Modifications to Accor Sofitel Hotel Site 4A, Olympic Boulevard Sydney Olympic Park

SECTION 75W APPLICATION

Submitted to: NSW Department of Planning

Date: 17 January 2007

Drawn: ES
Checked: KLB
Date: 105 111
Drawing Number: A-2002

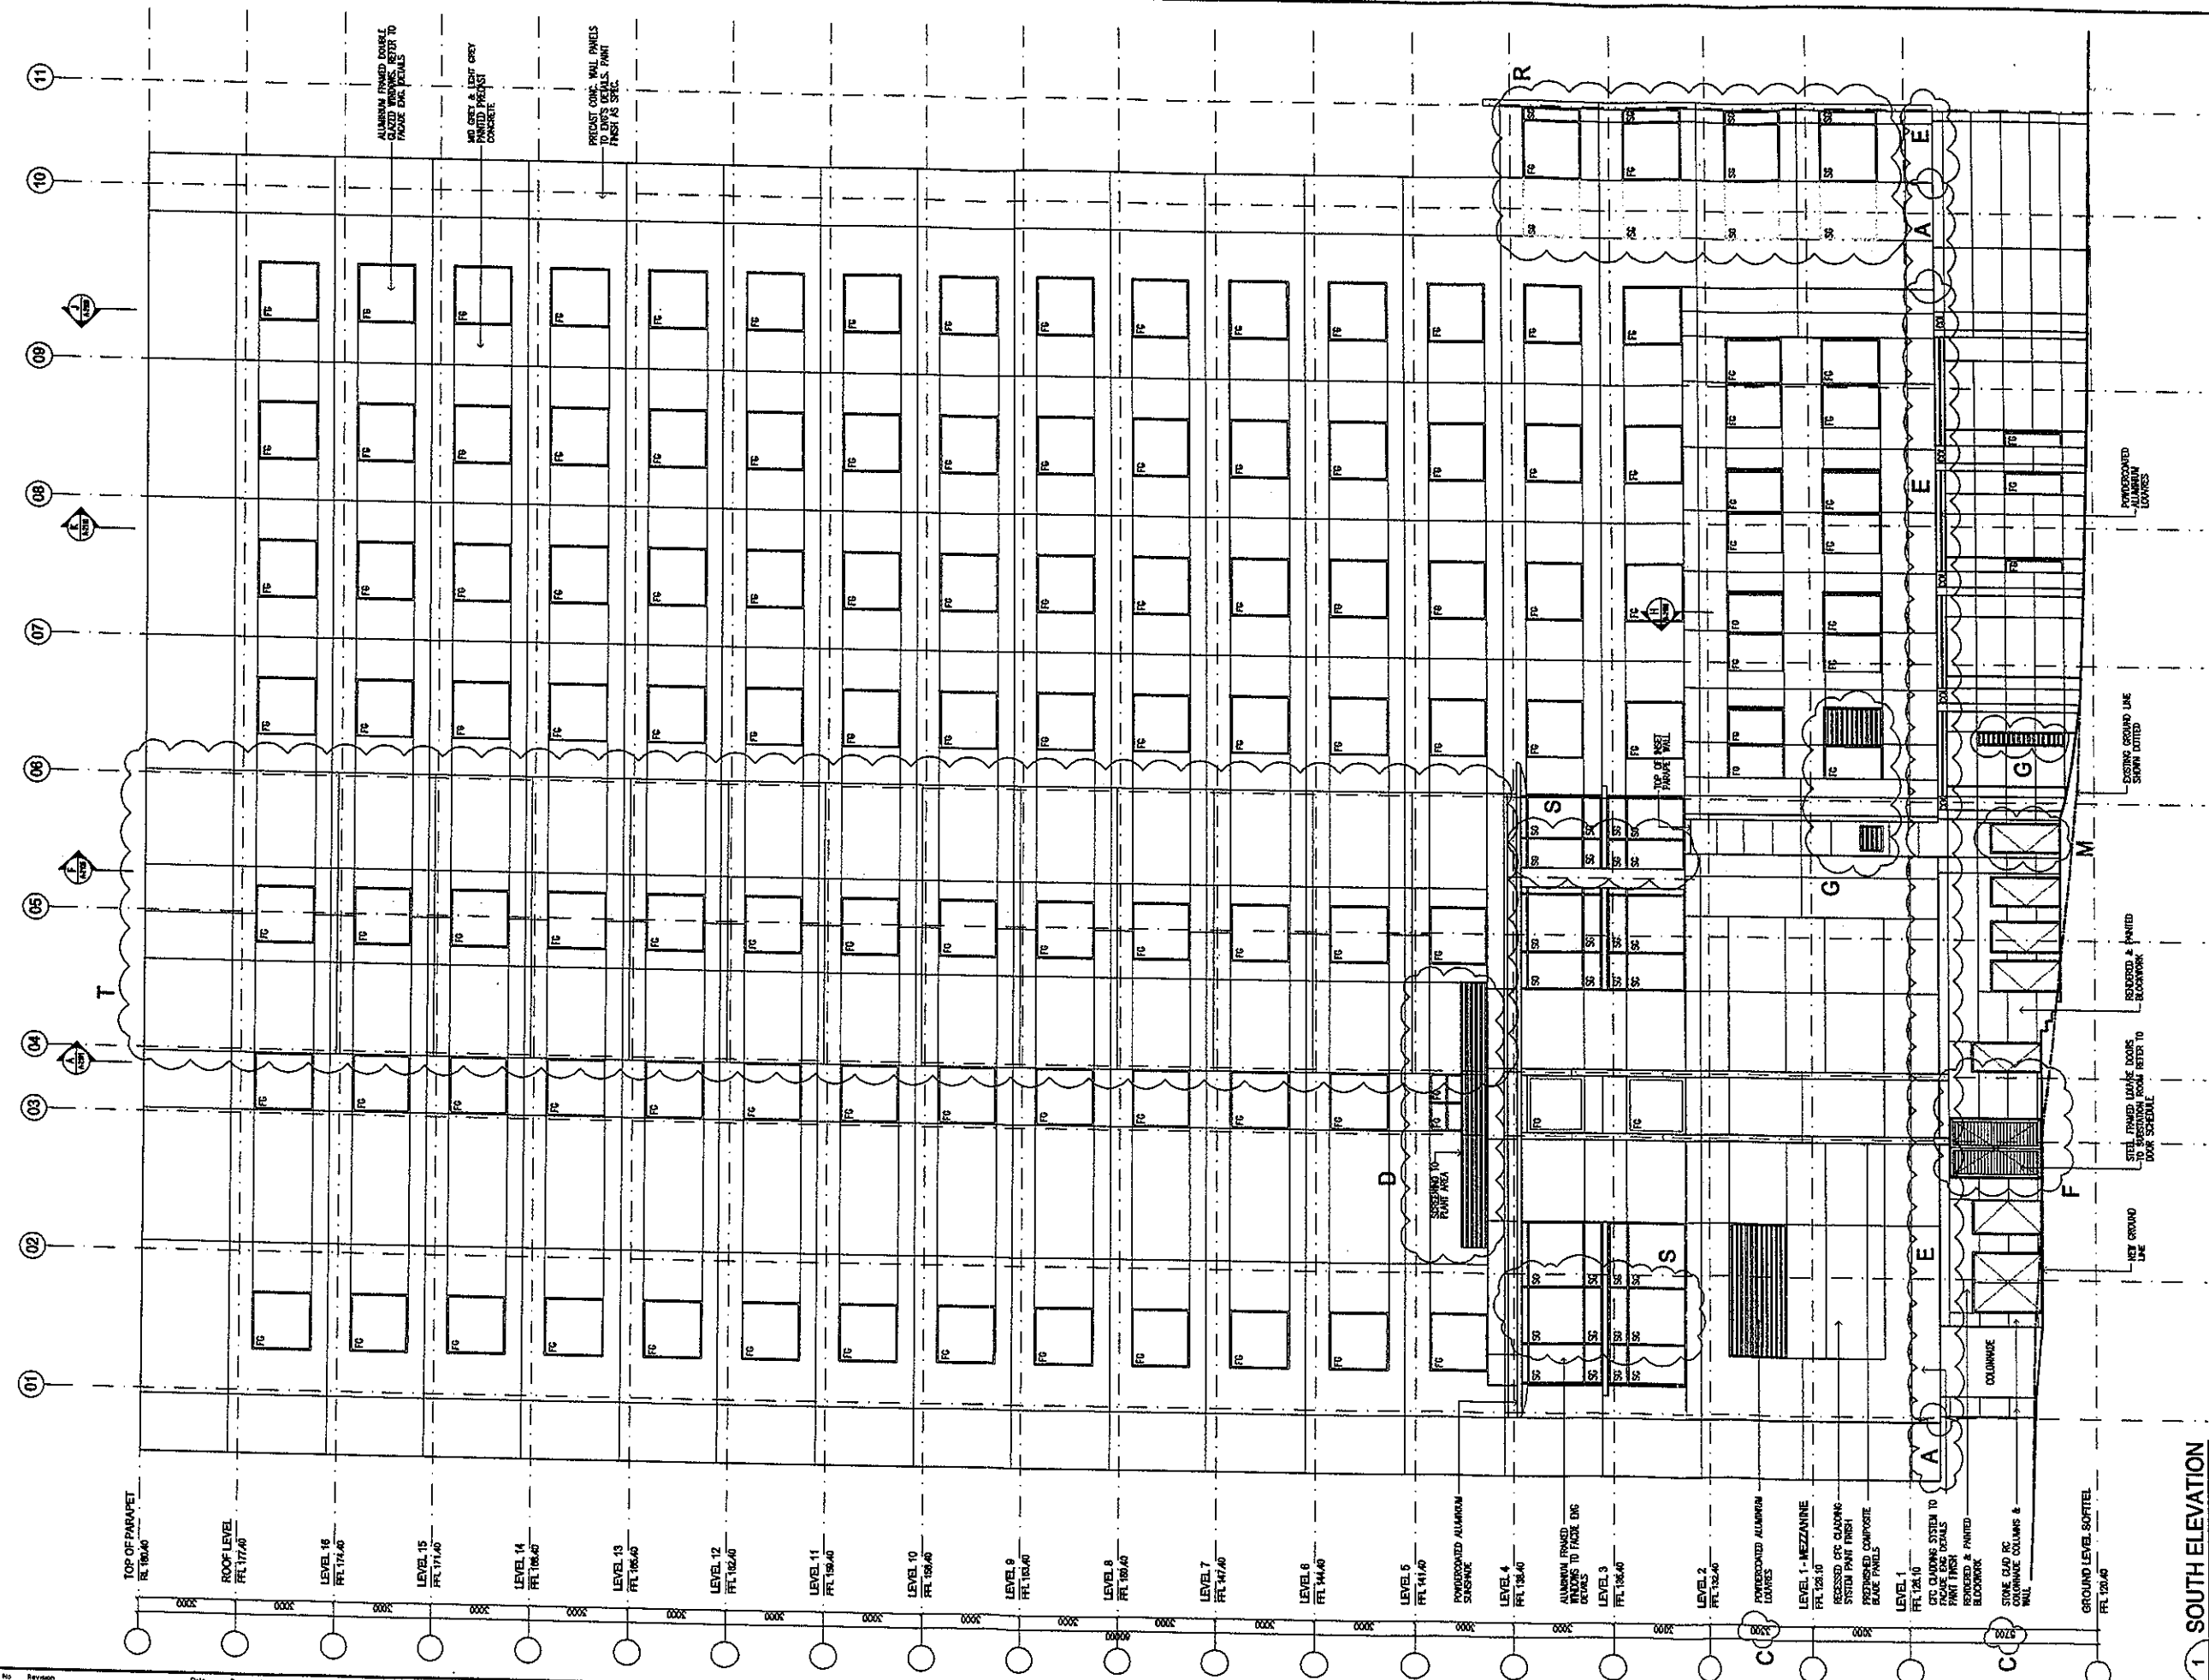
- A An increase to the floor to floor height of the mezzanine level by 300mm with a subsequent reduction in the floor height on the ground level also by 300mm. This modification has occurred to provide sufficient mechanical services reticulation to the public spaces on Level 1. There is no overall increase in the building height, simply an alteration of heights between the Ground Floor and Mezzanine levels to accommodate services. The effect of the modification is a drop in the hem of the precast panels of the main north and south facades.

- B Not used
- C Refer to comments in A. This is the subsequent increase in height of 300mm for the Level 1 Mezzanine.
- D Introduction of small plant items on the roof of the Level 4 podium which evolved during design development of the final services requirements. The plant will be screened from distant view using a powdercoated or equal finish open louvre system.

- E In reference to comment A, the baseline of the adjacent lightweight cladding was reduced by 300mm in order to maintain the original continuity of lines around the base of the building.

- F Following receipt of the final Energy Australia requirements for the substation, steel framed louvre doors are provided to the substation room. The feature blades above these doors were not intended to project as far and have been shortened to suit the requirements.

- G Inclusion of ventilation louvres as noted on the building facades.
- H The inclusion of steel struts at the top of the parapet above roof level. The struts will be finished in the same colour as the precast panels and the bulk of the structure is located below the adjacent lower parapet to eliminate the diagonal brace. The struts are required to support the cantilevered parapet walls. Further detail is provided on sketch detail SK-46 prepared by Hyder Consulting (See Appendix 2).

- M The fire control room door on the southern elevation is proposed to be deleted and relocated.
- N It is proposed to recess the proposed glass line of the entrance lobby to the left of the entry portal for one bay. This area is proposed to be utilised by the hotel concierge for the temporary location of luggage trolleys. The recess is proposed as a continuation of the colonnade.

- R Proposed modifications to the fenestration and louvre design as detailed on the plans.
- S It is proposed to replace the vision glass with spandrel glass on Levels 2 and 3. This is to achieve more satisfactory furniture arrangements and there is no change to the size or location of the windows.

- T It is proposed to modify slightly the panel joints in the precast system as noted on the attached drawings.
